From: [Dale, Louise Miss \(DIO Estates-SafegdgMgr2\)](#)
To: [Gregory, Michele](#)
Subject: 20190610: A303 Sparkford to Ilchester - Request for further information
Date: 10 June 2019 11:47:45
Attachments: [20190610 10044194 Yeovilton PINS Request FINFO-Final Draft.pdf](#)

Your Reference: TR010036
Our Reference: 10044194

Application by Highways England for an Order granting Development Consent

Examining Authority's request for further information

2.11 Outline Drainage Works Plans

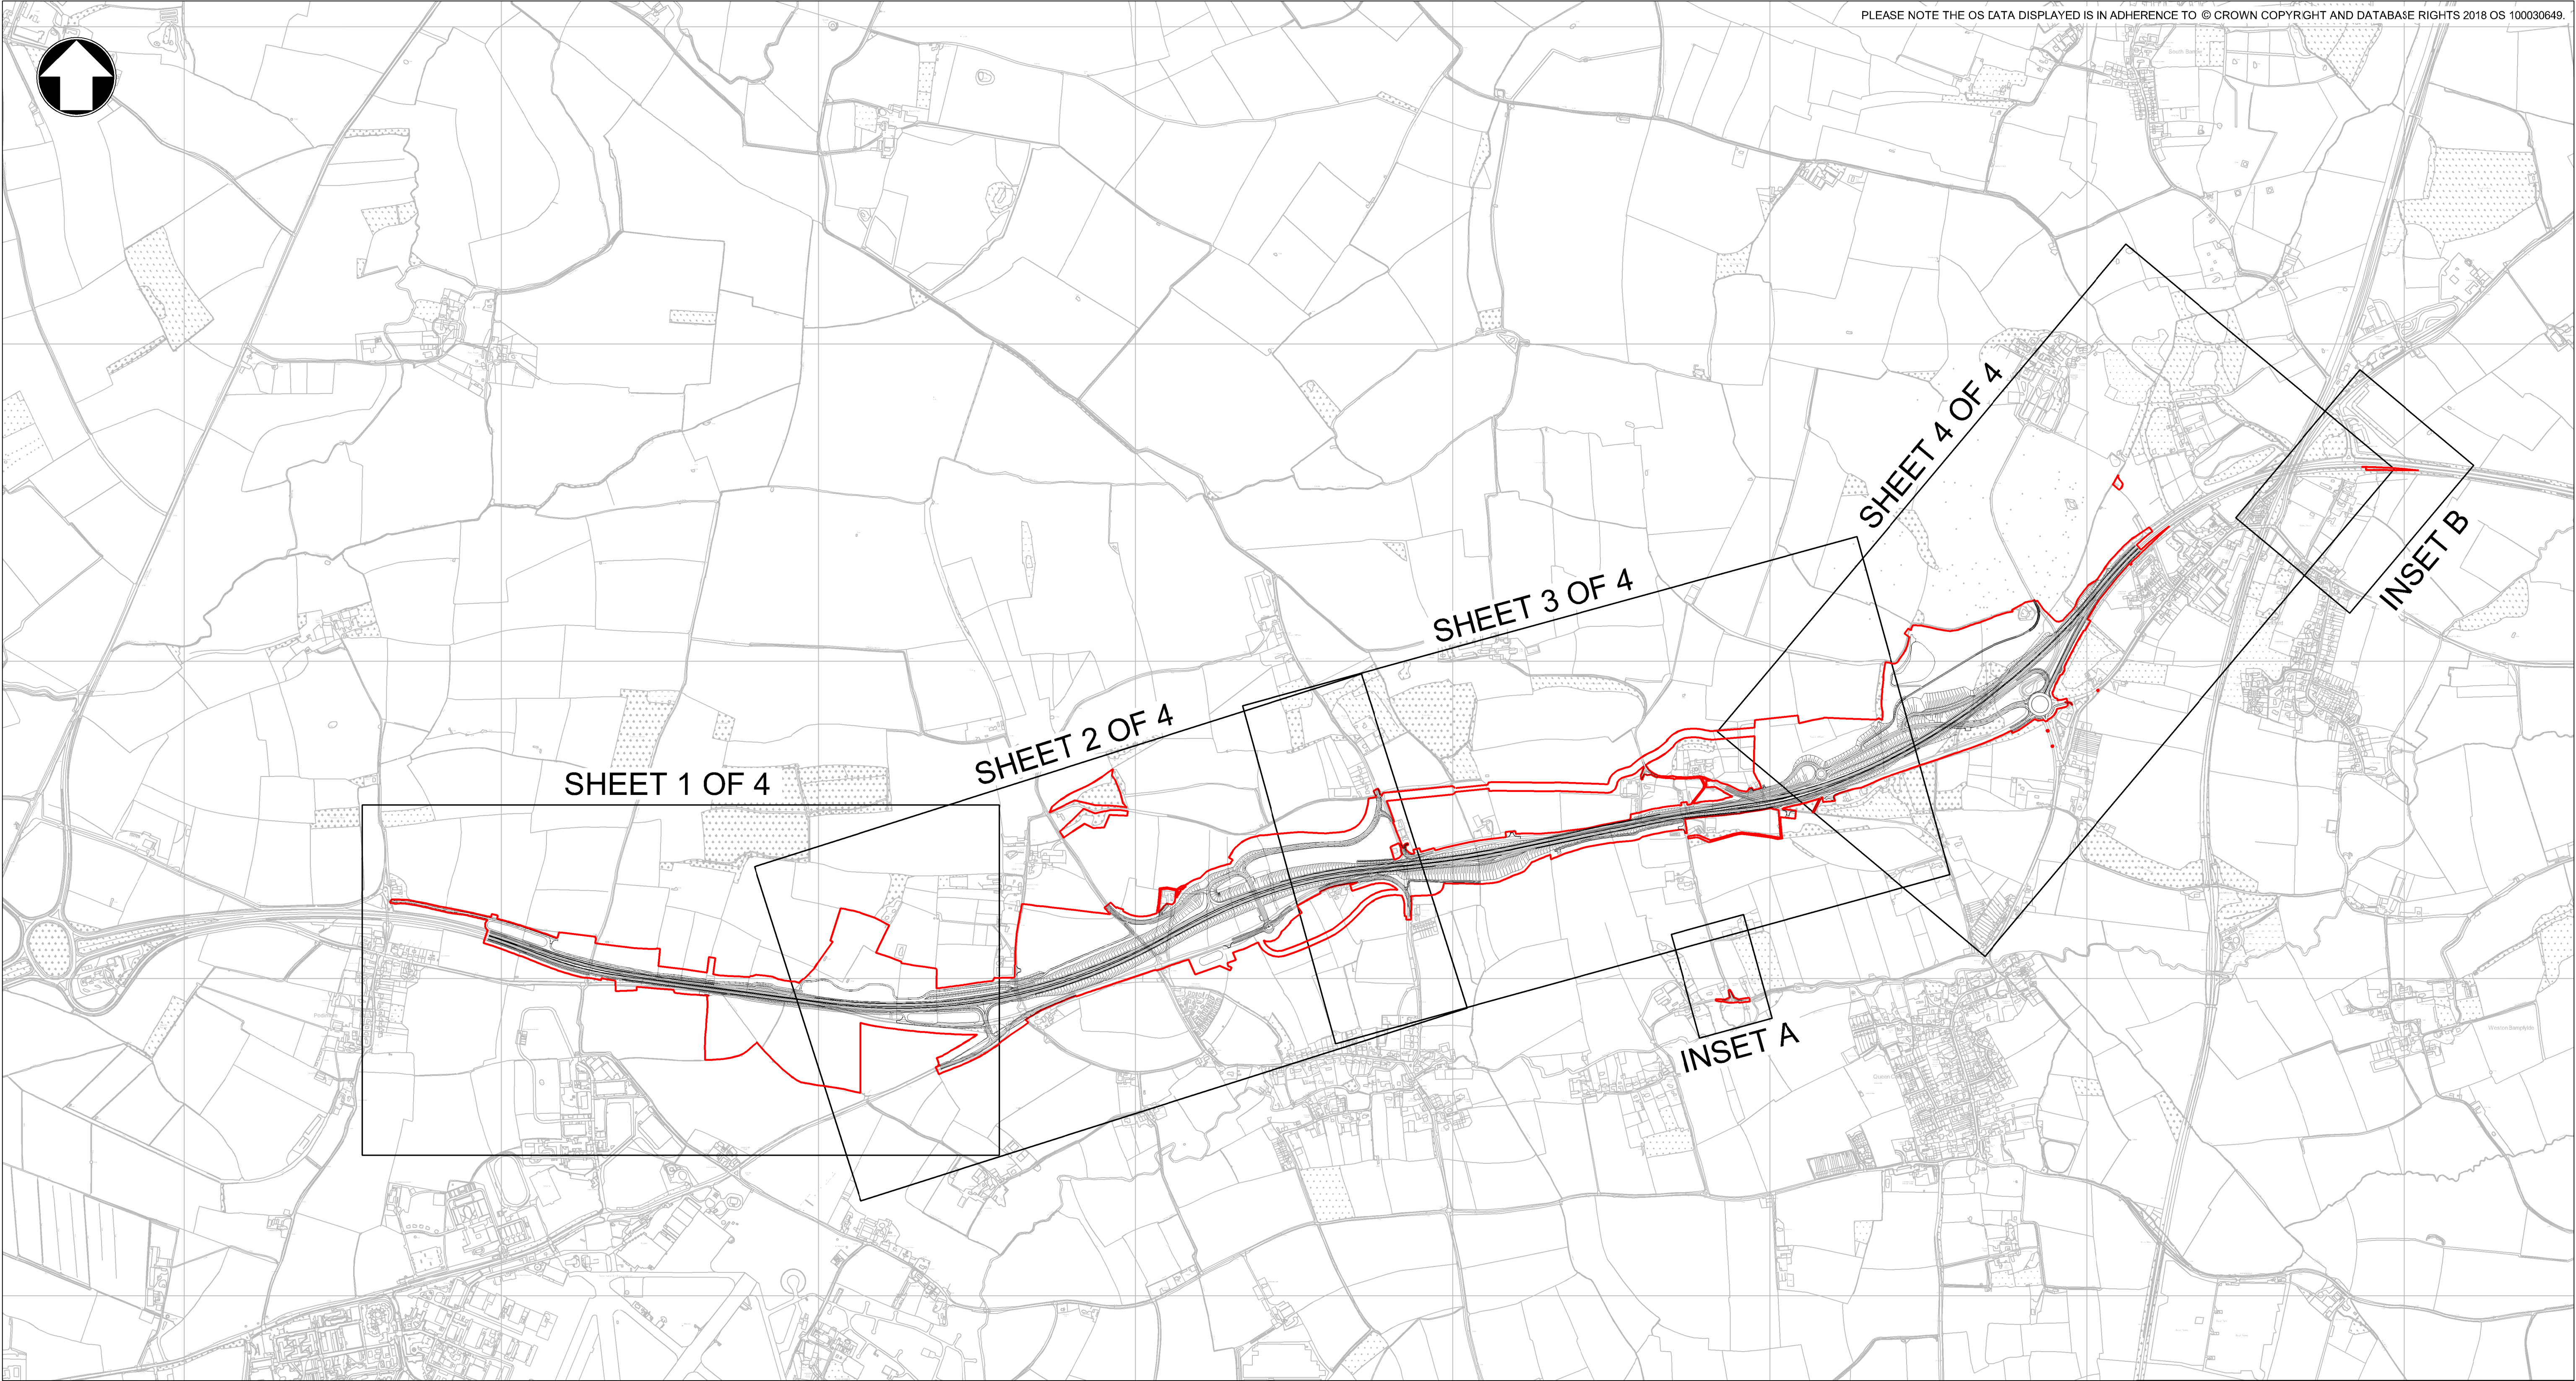
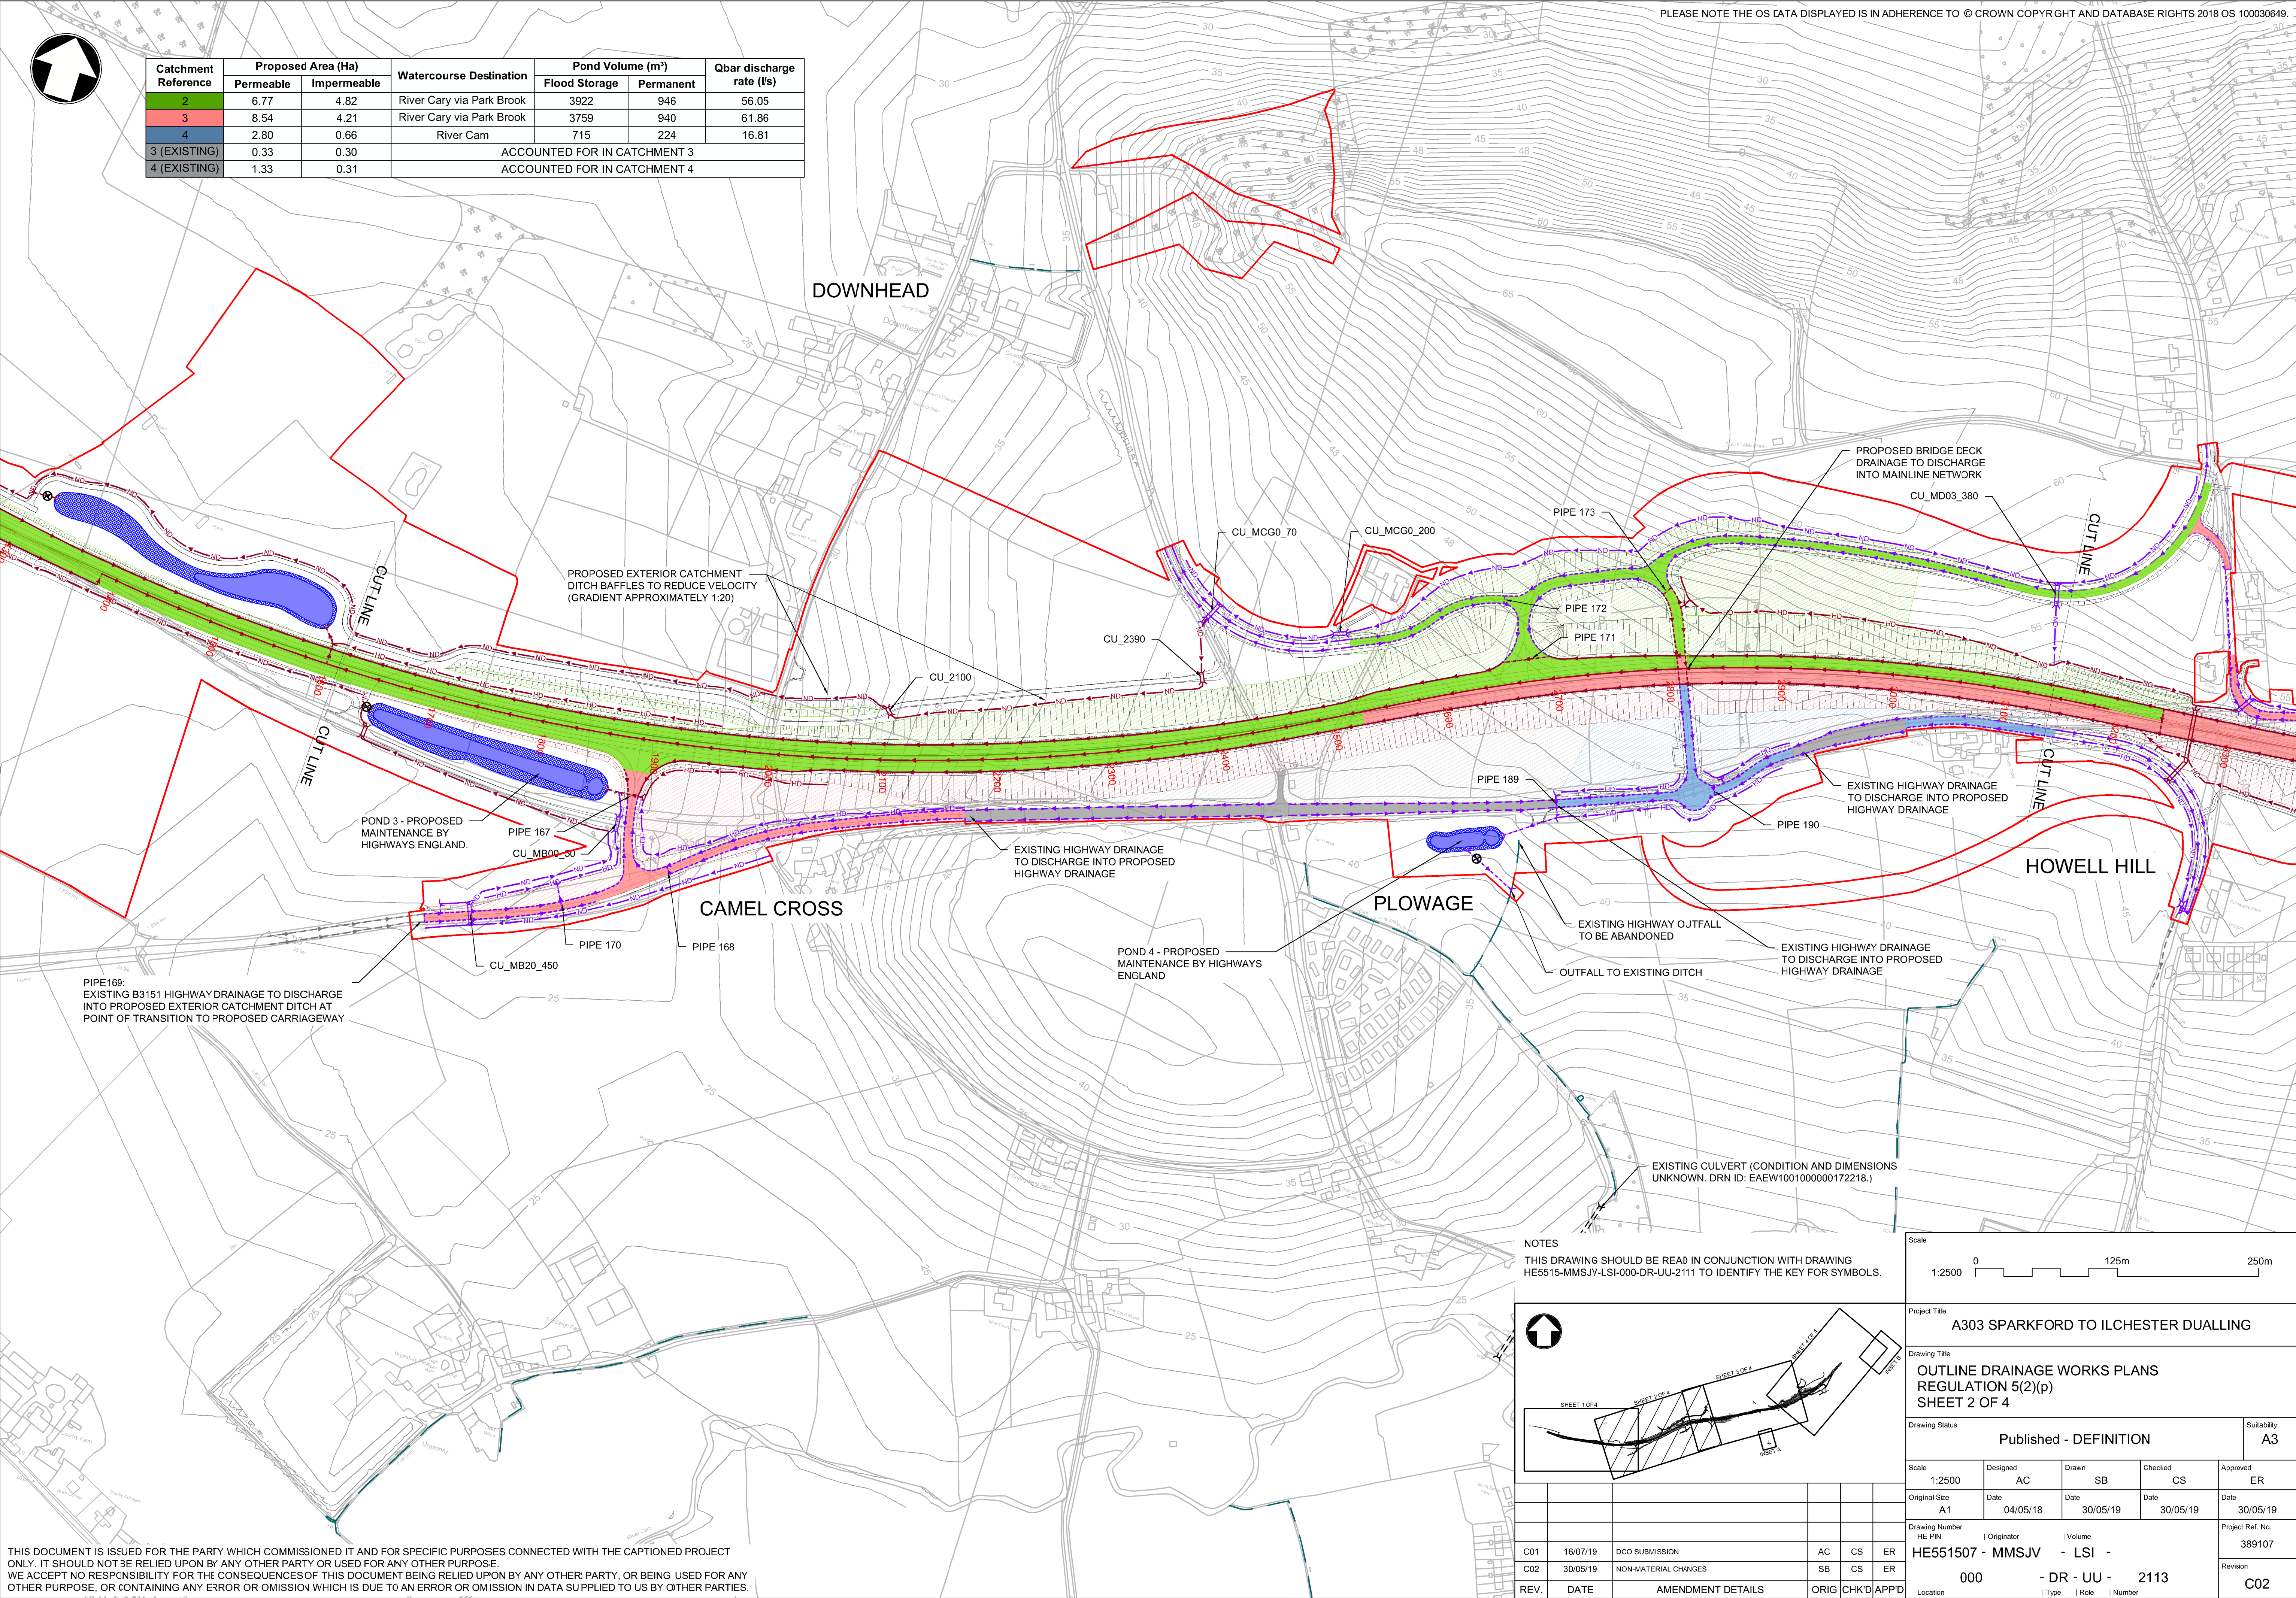
At present the Ministry of Defence (MOD) has statutory birdstrike safeguarding concerns regarding the proposed ponds. In particular ponds 1-3 as these water bodies are located beneath the approach into Runway 22 and the take off climb for Runway 04. Also, the recovery and departures routes from RNAS Yeovilton to Merryfield Airfield fly over pond 1 at 500ft.

The MOD concerns are based on the creation of open water bodies at these locations having the potential to increase the attractiveness of the site to existing flocking bird species such as gulls, starlings etc. These species are deemed hazardous to aircraft safety especially when in critical stages of flight.

DIO Safeguarding met with Highways England on the 9th May and identified our preferred option would be for the ponds to be predominantly dry and for the basins to dry down within 72hours following a 1 in 100 year storm event.

If Highways England could not achieve this, the MOD recommended how bird attractants could be *designed out* using the following principles:

Pond bank sides to be as steep as possible

- No visible area of open water, meaning the ponds are to be densely planted with marginal vegetation common reed (*Phragmites Australis* is the MOD's preferred option). This species of reed provides continuous year-round cover as it does not die back in Winter.

- A Bird Hazard Management Plan (BHMP) should be established and implemented for the maintenance of the reeds to prevent a starling roost. If a starling roost establishes, Highways England will disperse birds via appropriate licensed means. The BHMP should also cover the construction phase. Whilst works are being carried out the turning of soil provides exploitable feeding opportunities for flocking bird species, and water can gather in holes and voids during works. The management plan should include a commitment for Highways England to disperse bird species hazardous to aircraft safety.

On reviewing the information available the MOD's ornithological advisors determined that provided the ponds are designed in accordance with the recommendations outlined above, the size of the ponds and depth are satisfactory. They are not large enough to host a gull roost which would be a major birdstrike concern to the MOD.
